Rezoning Transportation Analysis

Petition Number: 2022-210

From: Jake Carpenter, PE
Jacob.carpenter@charlottenc.gov
980-221-5675

Date	Description
05-24-2023	First Review (PDM)
06-21-2023	Second Review (DR)

RZ-03

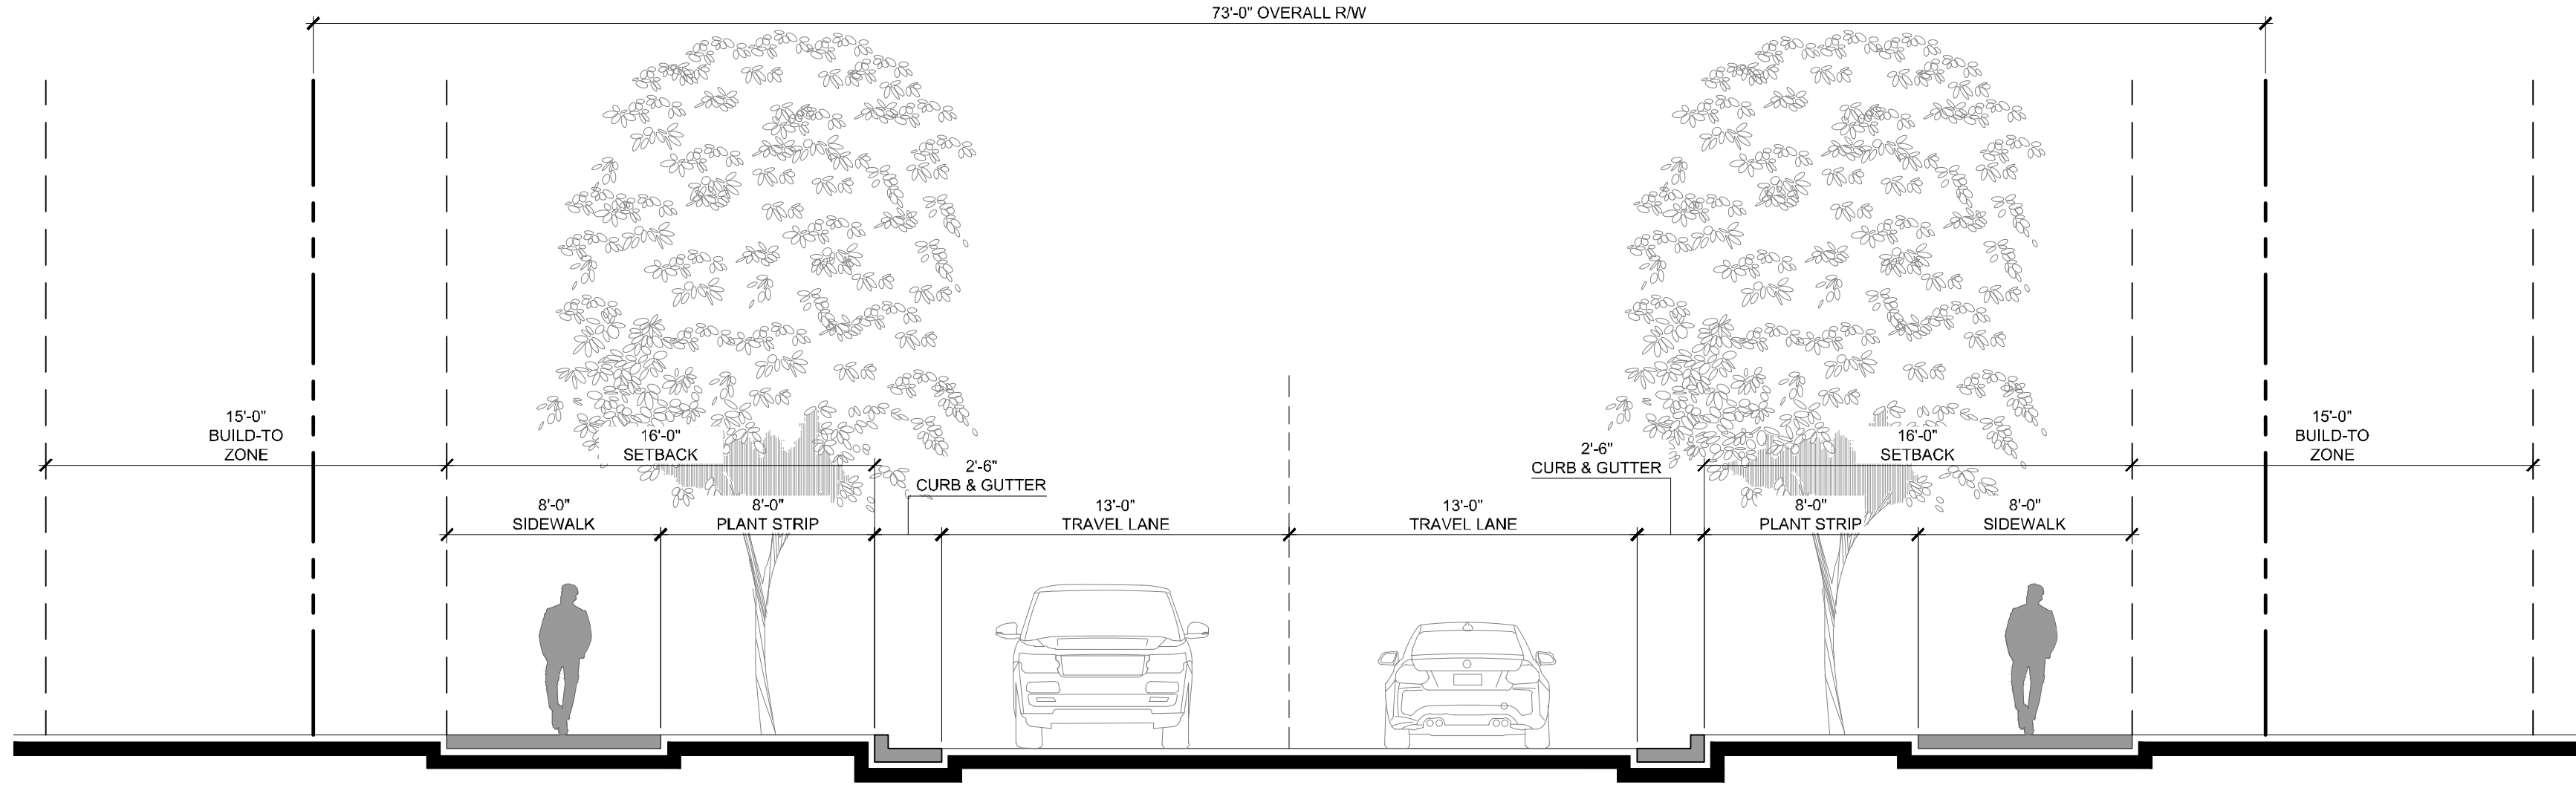
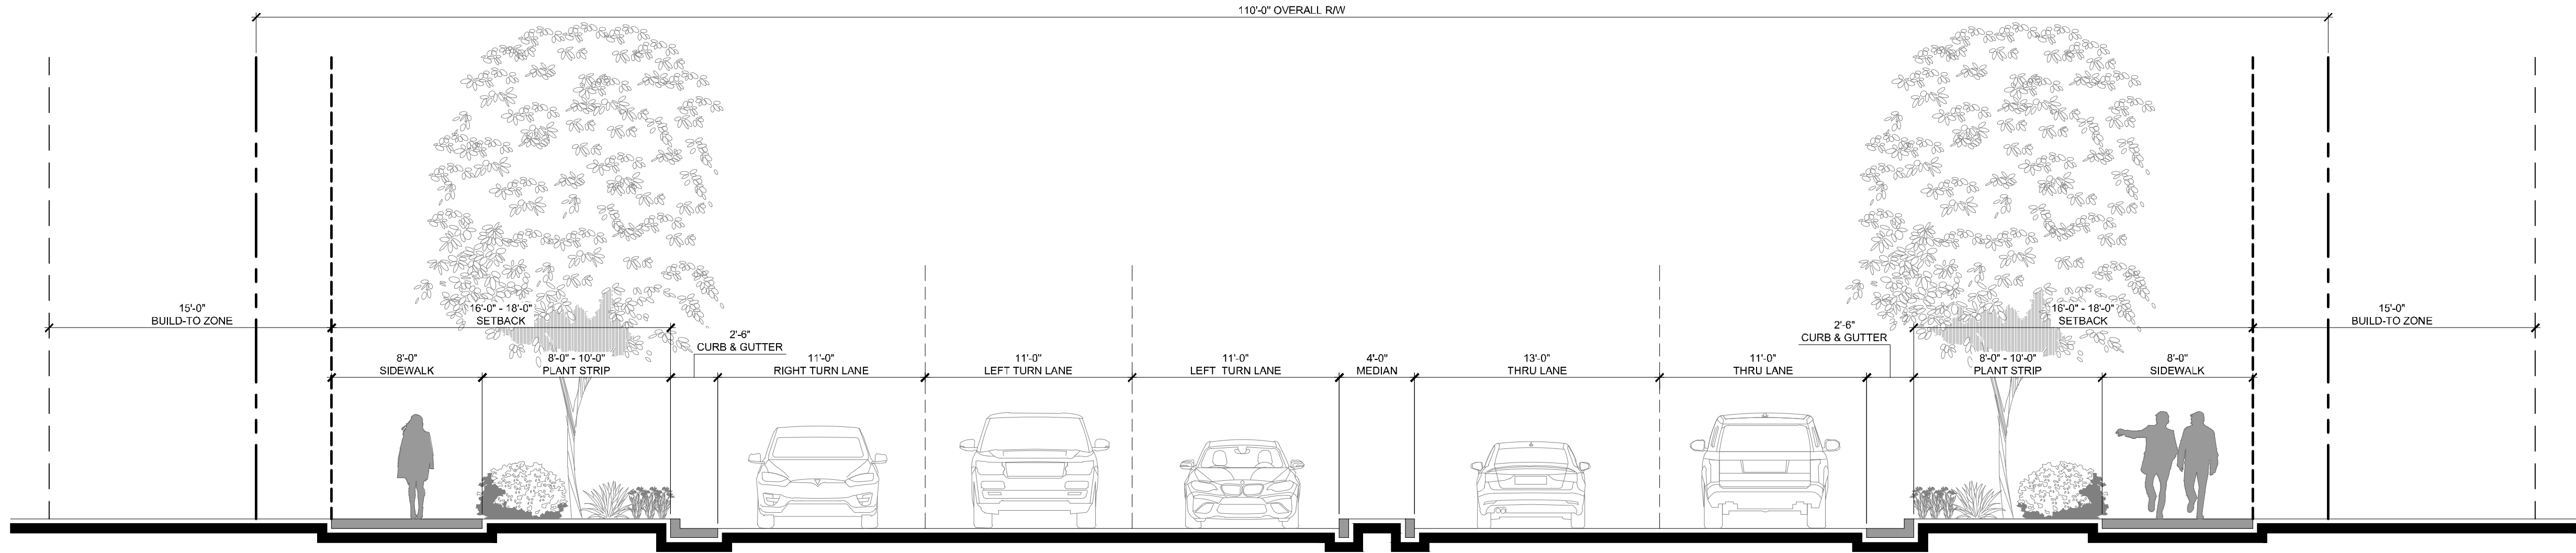
6. Revise internal street network to standard public street typical sections per the CLDSM or provide additional information on existing constraints for review and approval of nonstandard typical sections.

~~d. To allow modifications to the required public and network required street cross sections as generally depicted on Sheet RZ.03. Modifications shall be permitted between Trade Park Court from Tryon to end of existing cul-de-sac, and St Vardell from Clanton to Public Street B. On-street parking may be eliminated on one side of the street for up to 50% of the block frontage.~~
